**PERMIT NUMBER**  
**BRES2505-0077**

Description: **Change exist screened porch to a sunroom**

Parcel No: **0506-72-7222.000** Site Address: **230 HEATHER BROOK CIR SPRING LAKE, NC 28390**

DRAWINGS

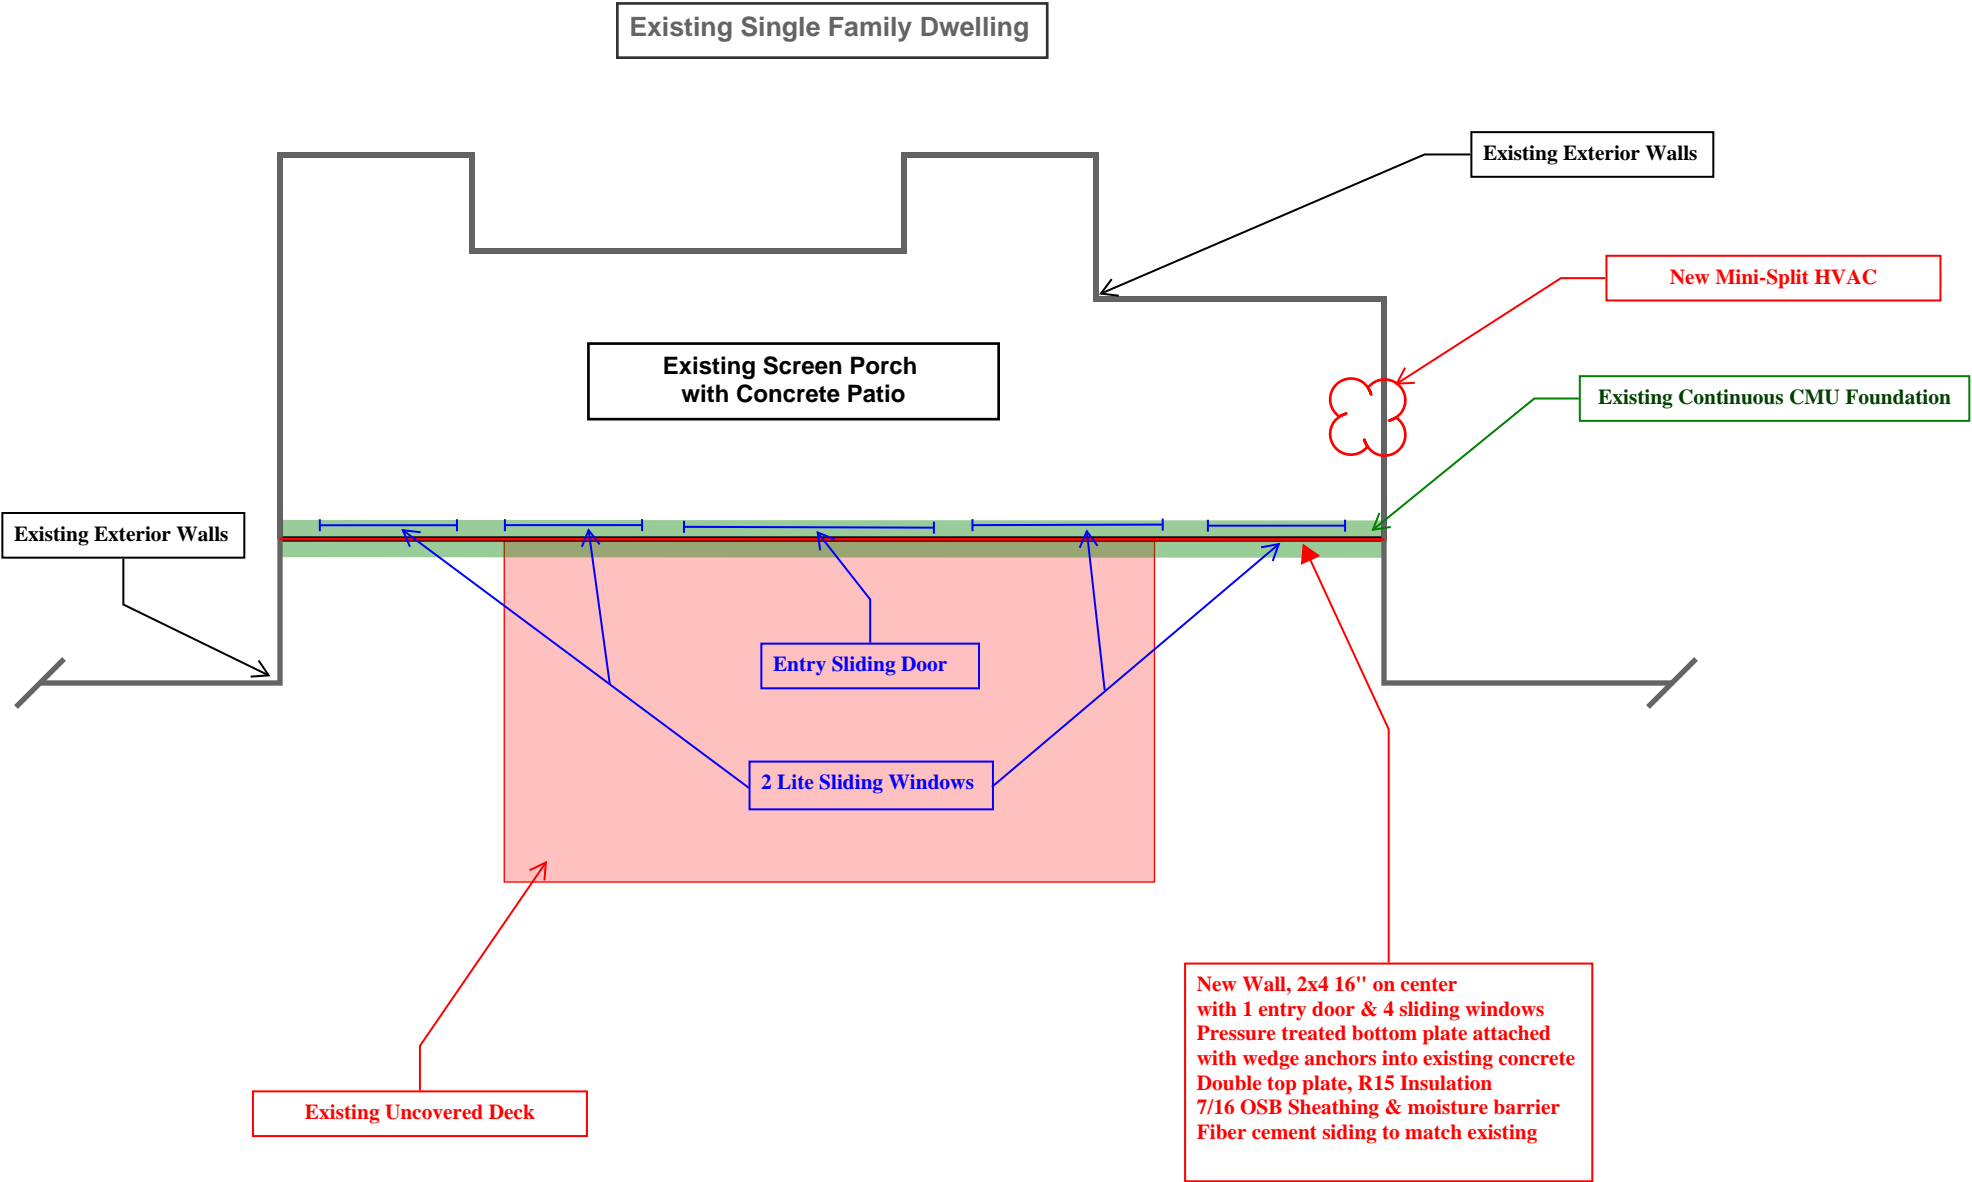
REVIEW TYPE	REVIEWER	SENT DATE	DUE DATE	RETURNED DATE	STATUS	REMARKS	NOTES
CENTRAL PERMITTING INTAKE	CP Bucket	5/22/2025	5/23/2025	5/22/2025	APPROVED		
RESIDENTIAL BUILDING	Brad Sutton	5/22/2025	5/28/2025	5/29/2025	DISAPPROVED	in attach	Verify no bedroom egress windows will be enclosed by this conversion, make a note on the plan, and sign and date whoever makes the note.
RESIDENTIAL BUILDING	Brad Sutton	5/29/2025	6/3/2025	6/2/2025	APPROVED	in attachments
